KITITAS COUNTY

MEMORANDUM

TO: All Staff
FROM: Public Works Plan Review Team
DATE: February 17, 2022
SUBJECT: BL-22-00003 Ozanich

The Public Works Department has reviewed the Request for Boundary Line Adjustment Application.

SHEET 1 OF 2

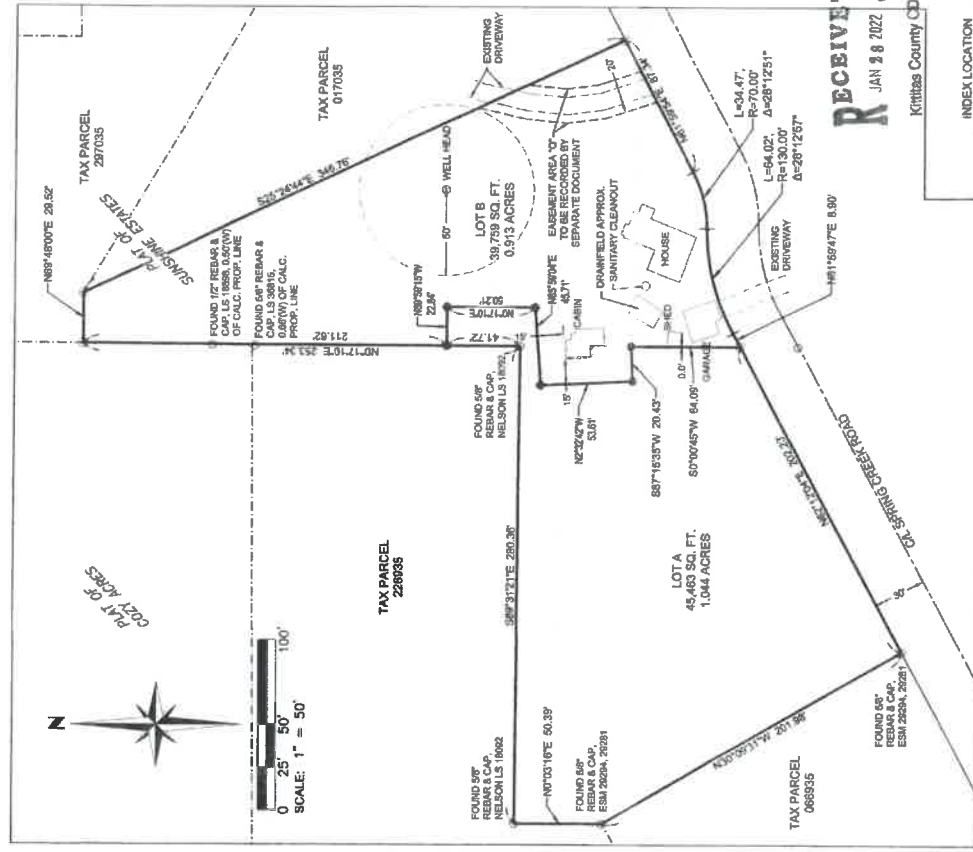
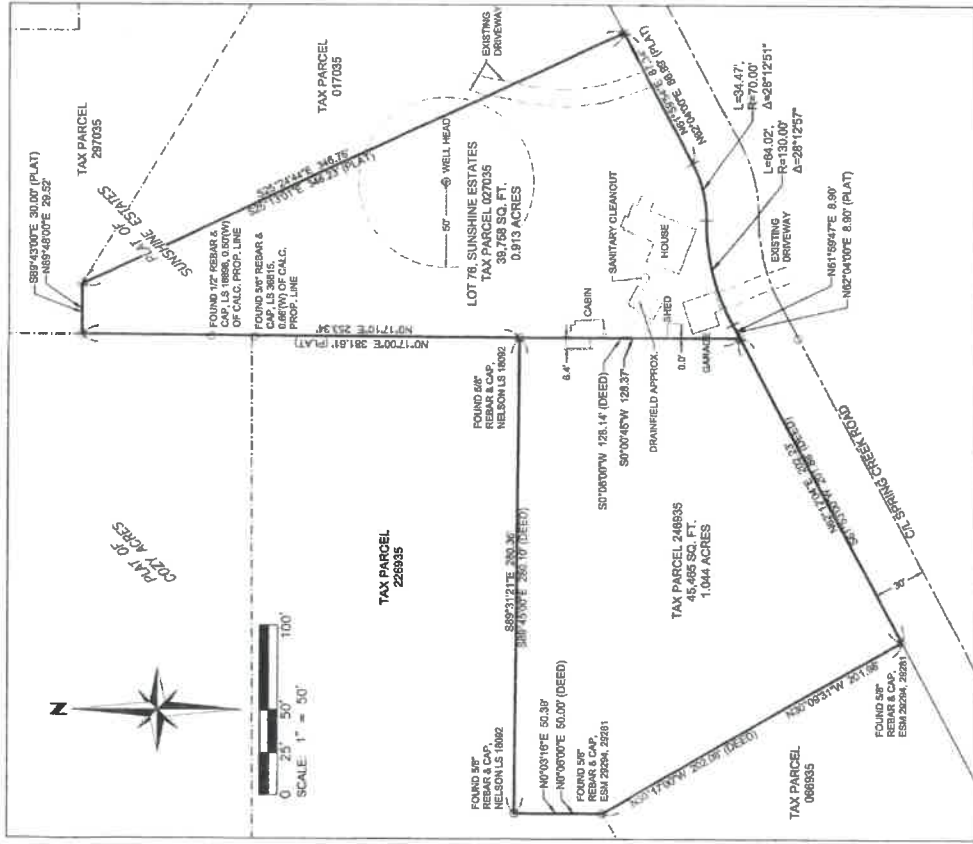
1. The reference note containing the purpose of survey should also identify the application number of BLA.
2. Error in legal description of Revised Lot A on survey:
“...Being the true point of beginning; Thence S62°12’04”E”
Should read S62°12’04”W or match label of line in map
3. All roadways must show underlying ownership (Private/County/State), easement or right of way and surfacing material.

It may be easier to view if deed dimensions were shown as (N89°02'13"E, 200.01 DEED) rather than N89°02'13"E, 200.01 (DEED).

It would be easier to retrace the legal if the Point Of Beginning of the deed was shown together with ACTUAL deed calls, rather than mathematical reductions of the deed calls along the current boundaries.
